Sizewell C (SZC)

Planning Inspectorate Reference: *EN010012*

Written summary of oral case

ISH 6 Coastal Geomorphology, 14 July 2021

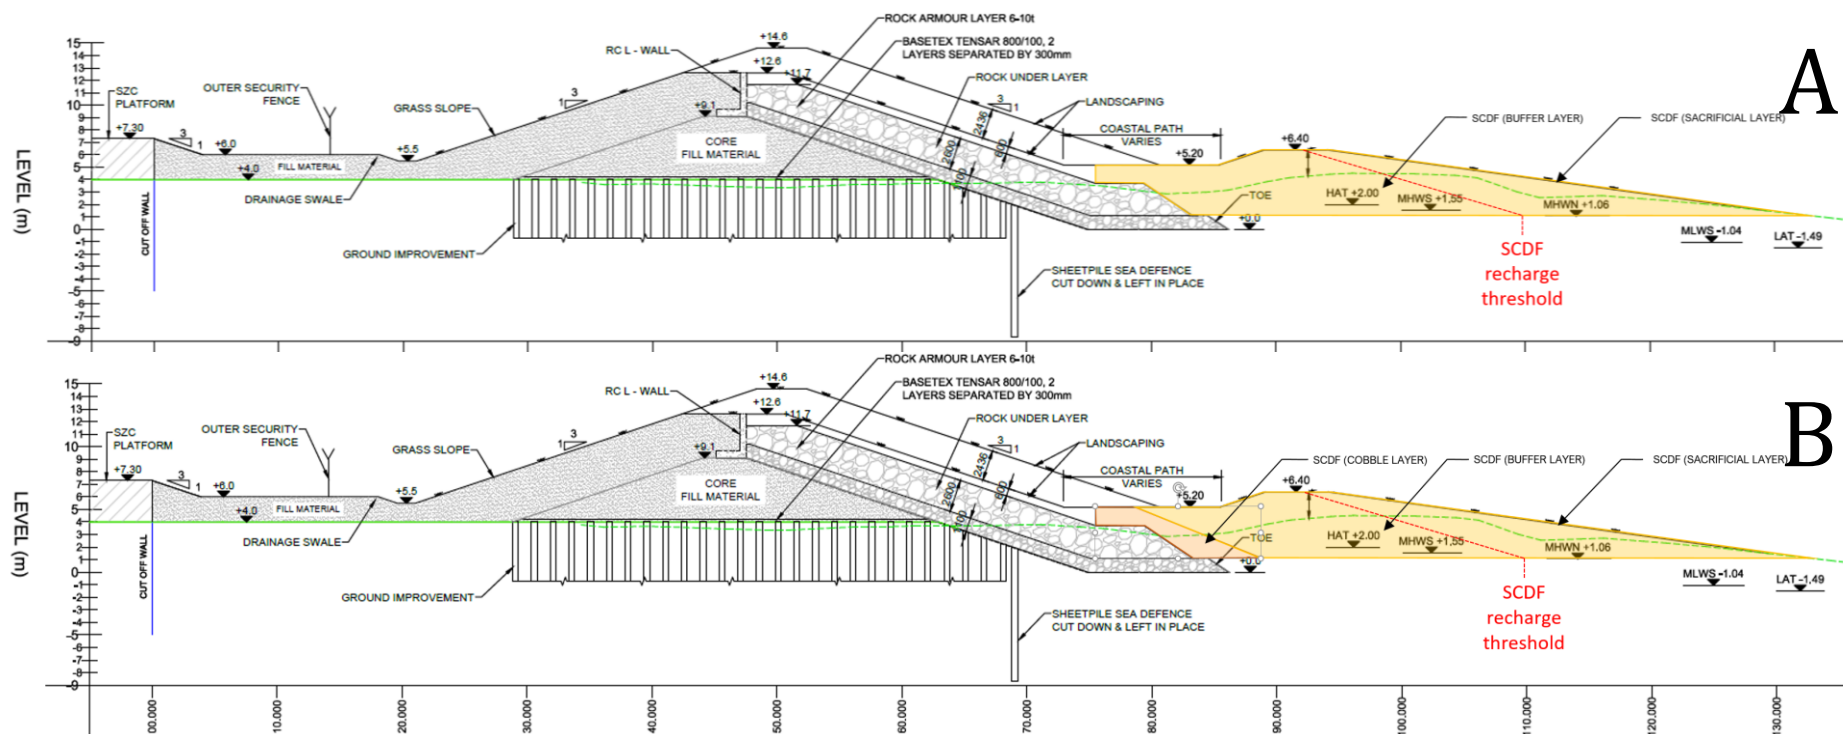
<p>Secondary mitigation is not yet fully defined, and we understand that the CPMMP [AS-237] will be updated and provide further detail of this. All matters mentioned here are contained in our written submission.</p> <p>ESC wishes to establish a default position that the HCDF should be removed at the decommissioning phase. The site funding plan should be based on the premise that this feature will be removed subject to future assessment confirming otherwise.</p> <p>4 (a) (i) The plan position of the HCDF</p> <p>The current alignment of the HCDF is further seaward (by approximately 40-50m) than the Sizewell A and Sizewell B equivalent defences.</p> <p>The seaward extent of the HCDF rock slope is shown in REP3-004 as having advanced over the central standard Sizewell C frontage by 8m compared to the May 2020 proposal. ESC has requested that the Applicant revisits its assessment of the HCDF plan location to demonstrate minimum seaward advancement and understands that further details to be provided at the next deadline will show a landward movement of parts of the HCDF.</p> <p>4 (a) (ii) The risk of further seaward advance caused by coastal change.</p> <p>The underside level of the proposed HCDF seaward foundation structure is at ~MSL. This is untypically high by conventional design standards for rock armour slopes on the Anglian coast. ESC is concerned that this high foundation level makes the structure vulnerable to undermining and may require premature / avoidable Adaptive works if coastal change over the site life renders the SCDF unviable.</p> <p>This is relevant to coastal processes because the current design remedy for an inadequate HCDF foundation level is the Adaptive design that will overlay and extend the HCDF foundation by a further ~20m seaward.</p>

DRAWING TITLE:
PERMANENT COASTAL DEFENCE FEATURE
TYPICAL SECTIONS (MAIN)

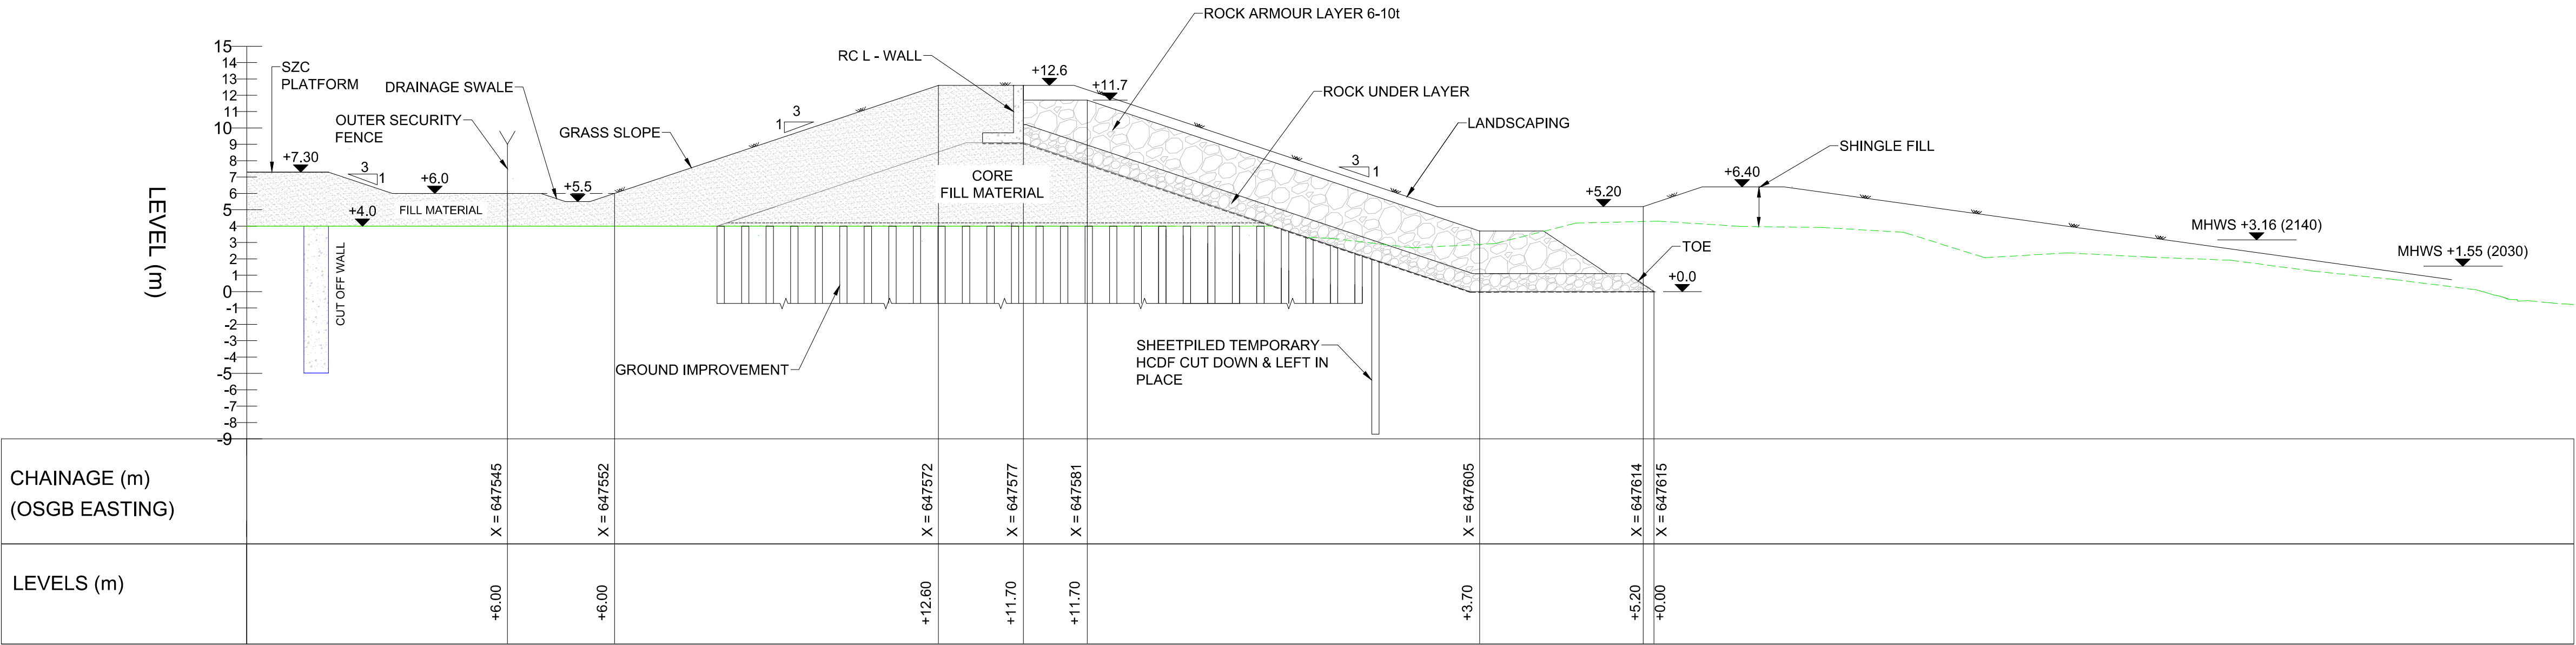
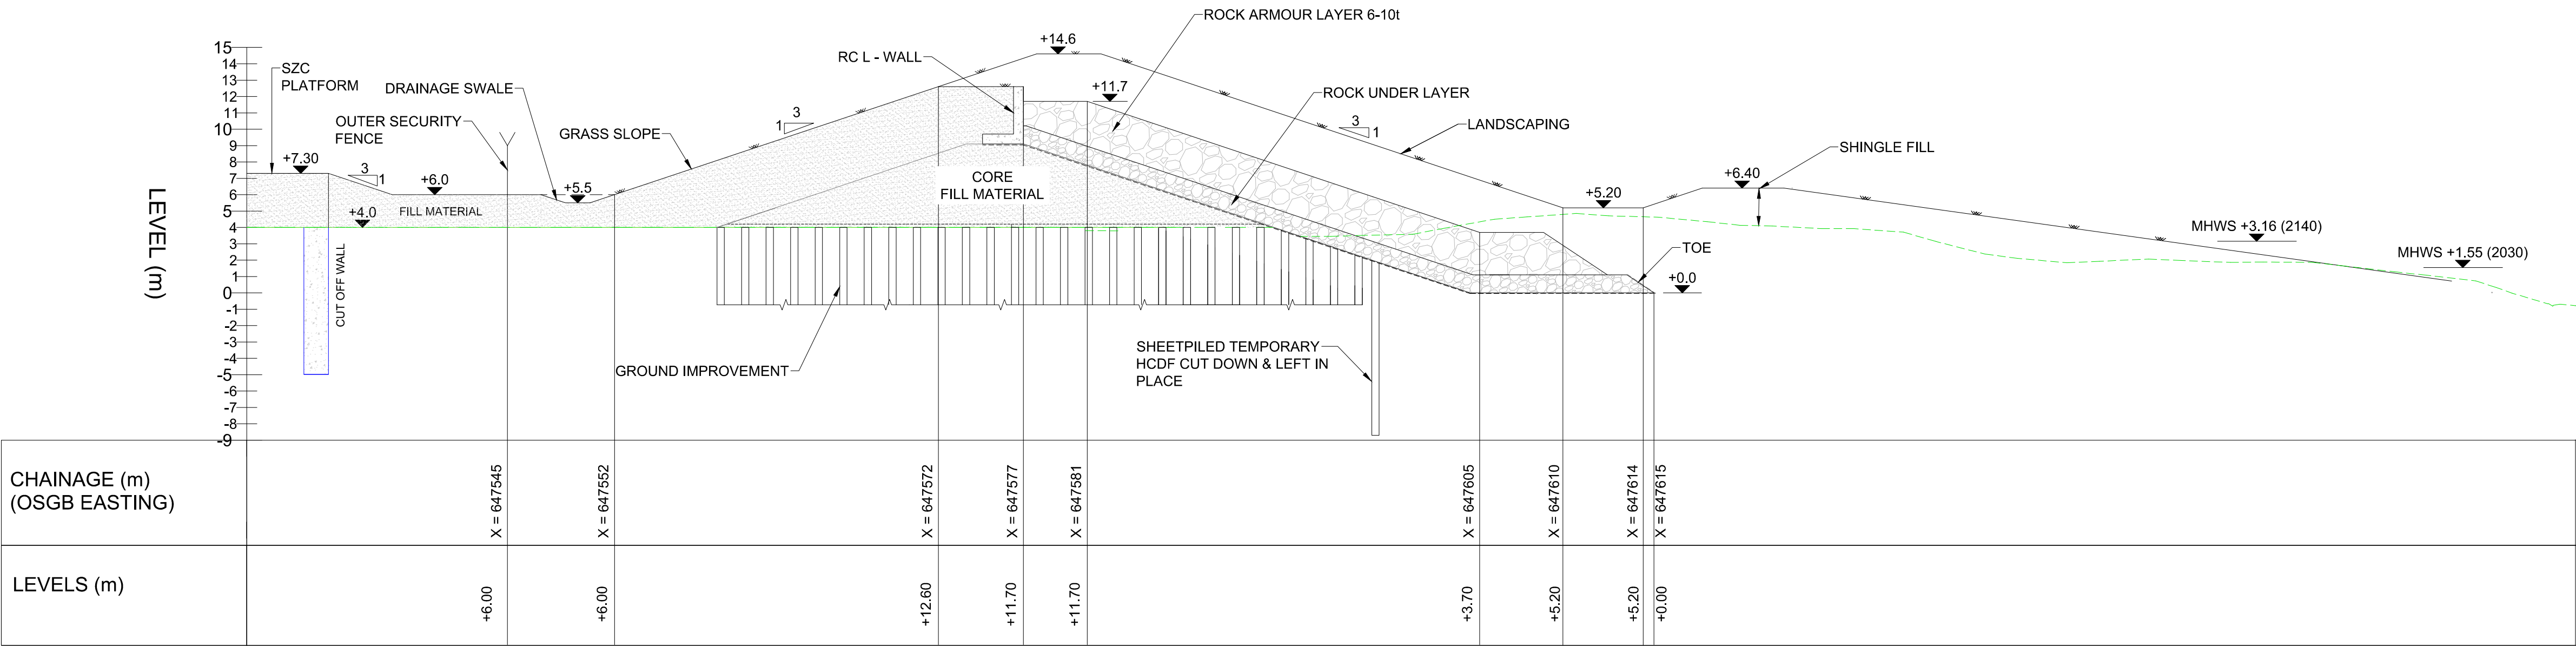
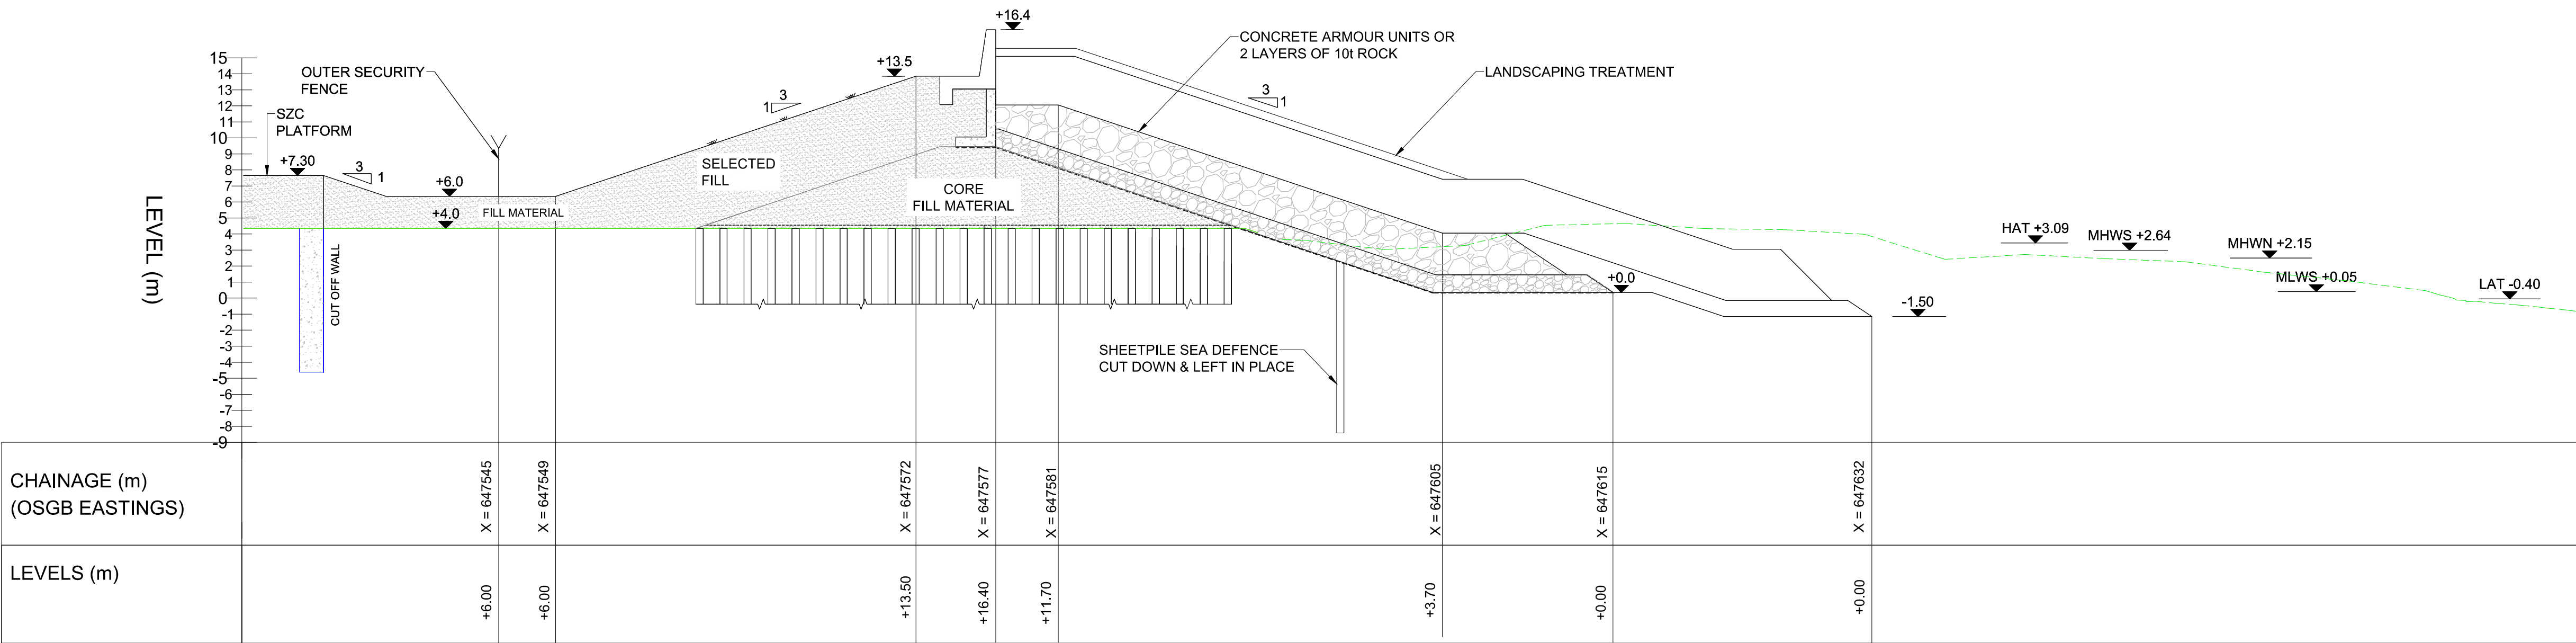
<p>In the Design Report REP2-116 the Applicant has assessed the proposed foundation level to be resilient to future coastal change. The Applicant believes there is no risk of an Adaptive profile being triggered by coastal change because a SCDF will be maintained to seaward of it and the HCDF foundation is secure over its design life. This matter is under discussion with the Applicant.</p> <p>4 (a) (iii) The SCDF is a more substantial and resilient structure than proposed in the May 2020 DCO.</p> <p>The developing design is for a 'engineered' non-native beach feature with potentially 3 defined layers (cobble, buffer shingle and sacrificial shingle) increasing in size and resilience toward the HCDF face. ESC is concerned that the current SCDF design is departing from the original concept that it would be a maintained natural shoreline using reclaimed material, similar in nature to beaches to either side, that would be distributed along and across shore. (TR311 3.2.2 [APP-312])</p> <p>Making the SCDF more erosion resistant could be expected have two principal effects: reducing the volume of sediment to feed the adjacent shoreline and reducing the rate of landward migration of the SCDF through erosion and/or overtopping of shingle.</p> <p>TR545 REP3-048 also illustrated an option for a Type B HCDF which would be the same as Type A, but for the inclusion of a "Cobble Layer" - a 5m width of fine cobbles at the toe. In effect this would present a further 5m seawards extension of the HCDF or more, should the cobble layer collapse under wave attack (possibly the intent as a contingent measure to limit bed scour).</p> <p>ESC's preferred position is for the SCDF design to provide a sacrificial surface layer that is able to be mobilised by waves and tidal currents in a fashion that is comparable to adjacent beaches. This will probably require a higher level of management, and investment, by the Applicant than the most recent draft design. This is under discussion with the Applicant.</p>

<p>4 (a) (iv) The Applicant has identified the HCDF may undergo design Adaption during its life that will overlay and extend it seaward by 17m and create a new foundation underside level of 1.5m below ordnance datum. This will be triggered by monitoring of sea level rise trends and will result in a higher standard of flood protection for the site.</p> <p>The Design Report suggests that the SCDF will be maintained to seaward of the Adaptive HCDF. ESC has asked for evidence from the Applicant that this is viable.</p> <p>ESC has queried the 'buildability' of an Adaptive profile many decades into the future when shoreline change may have made the HCDF intertidal part a marine structure, REP3 032, REP2 116.</p> <p>ESC objective is to avoid construction of a modified HCDF that will extend ~17m further seaward and increase the potential for a major negative impact on coastal processes by breaking the shoreline sediment pathway, APP-312. This matter is under discussion with the Applicant.</p> <p>4 (a) (v) The Permanent and Temporary Beach Landing Facilities are jetties that allow the seaborne delivery of abnormal indivisible loads (AIL) and bulk construction materials, respectively. ESC is now generally satisfied with the conclusion of the Applicant's assessment that the BLFs are not likely to cause a significant adverse impact on coastal processes, subject to the proposed mitigation as part of a managed SCDF.</p> <p>4(a)(vi) ESC believes the HCDF should be removed when no longer required to protect nuclear site infrastructure. The HCDF will require substantial mitigation to avoid it causing significant interruption to coastal processes during the station life. The potential harmful impact, and mitigation effort, will increase over time. ESC considers that the default position should be that the HCDF will be removed, subject to assessment at the time of decommissioning.</p>
